Monday 3 November 2025

Proposal: Conversion of former mill to form 5 apartments including extension and alterations, demolition of outbuilding, construction of 4 no open sided car port structures and associated works.

Location: Bankgate Mills, Bank Gate, Slaithwaite, Huddersfield

Waterway: Slaithwaite Output Feeder

FILE NAME: dwg-tjba-garside-dev-bankgate-mills-250722 SCALE: 1: 100 @ A1

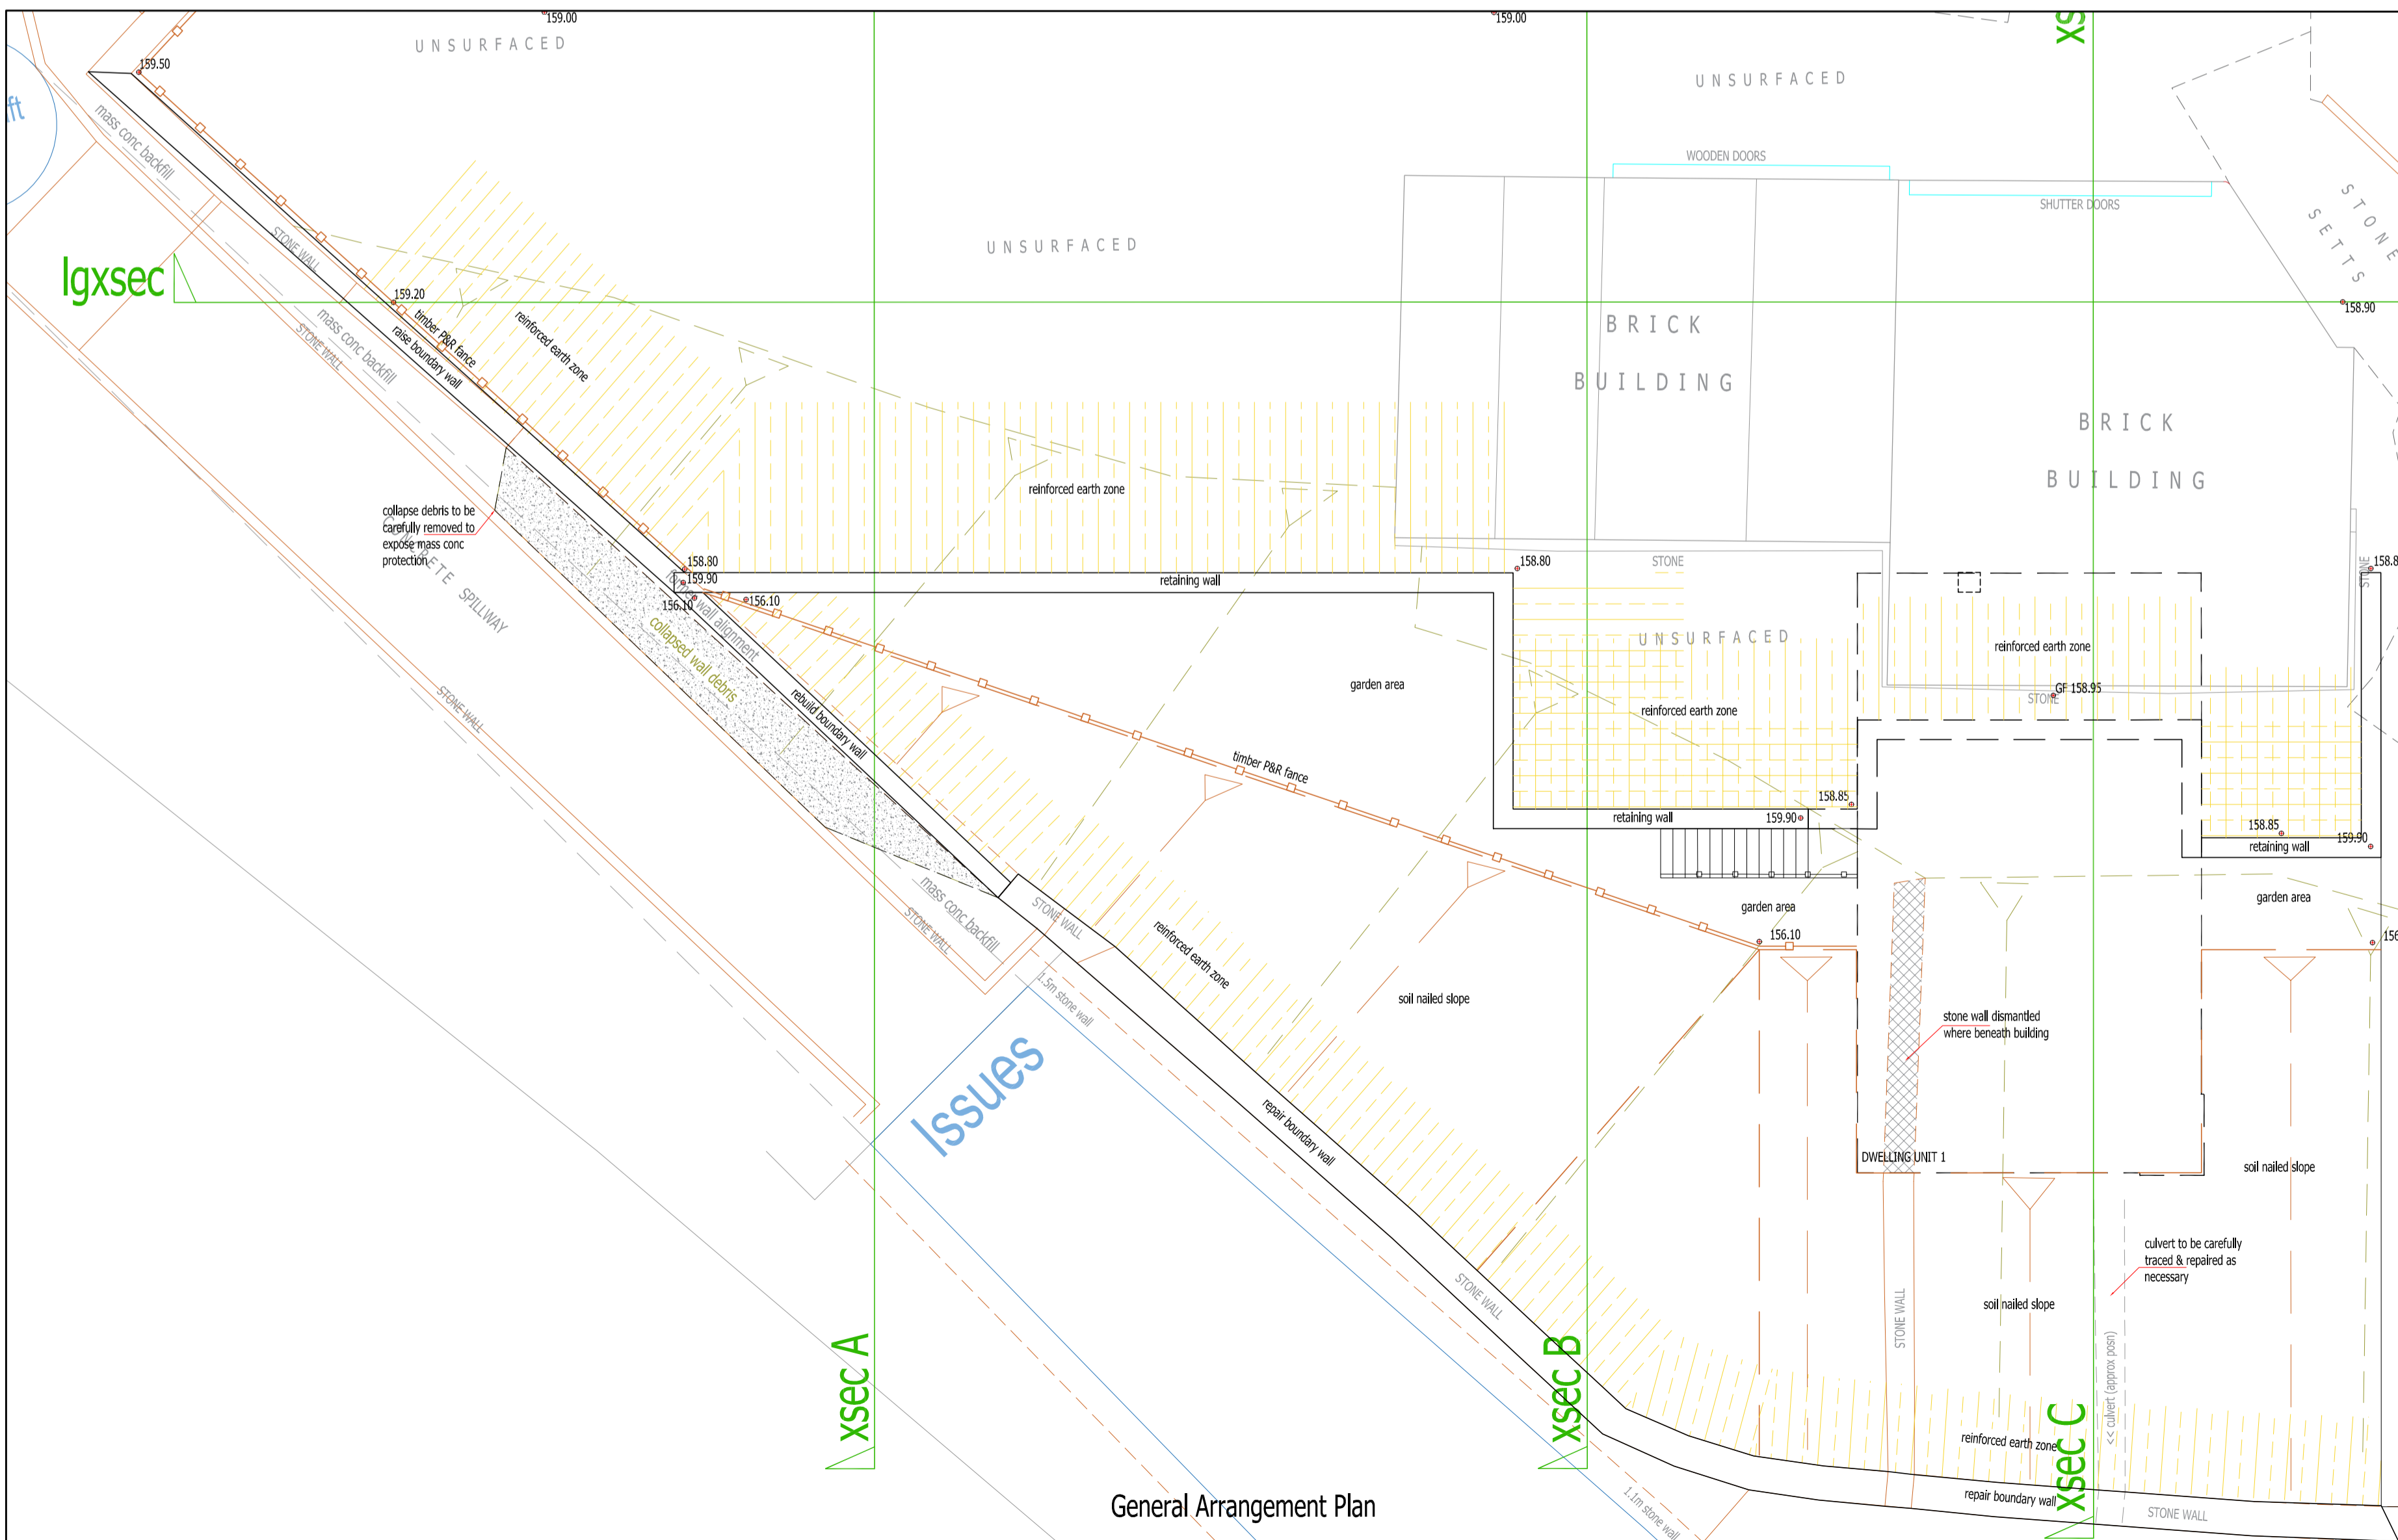
The Trust has previously requested calculations to demonstrate that the land upon which the development is sited can be made stable to ensure a safe development. In our previous response, dated 8th October 2025, the Trust raised comments in respect of calculations provided by the applicant, upon which we were consulted on 23rd September 2025. These comments requested the provision of additional details upon:

- The cross-section angle upon which the calculations were based;
- Calculations concerning the toe retaining wall; and
- Details concerning the impact of drainage works.

To clarify, we consider that the analysis of overturning around the toe can be considered the worst case scenario, and that analysis of overturning of blocks higher up the wall is not required; and that it is confirmed that free draining backfill material to the new wall will be included to allow groundwater to drain towards lower ground.

“Works to stabilise the slope to the South West of the site shall be carried out in accordance with details submitted in Drawing 250722Rev0 and the Structural Survey by TJ Booth Associates both received by the Local Planning Authority on 23/09/2025 and the Structural Calculations by TJ Booth Associates dated 23/10/2025. Upon completion a verification report by a suitably qualified practitioner shall be submitted to and approved in writing by the local planning authority to confirm completion of the stabilisation works before the development is occupied.”

In response to the additional details received, and clarifications from the applicant's consultant on the proposed earthworks, **the Trust is satisfied that the earthworks proposed by the applicant reduce risks of land instability that could otherwise impact the safe operation of the reservoir spillway.**
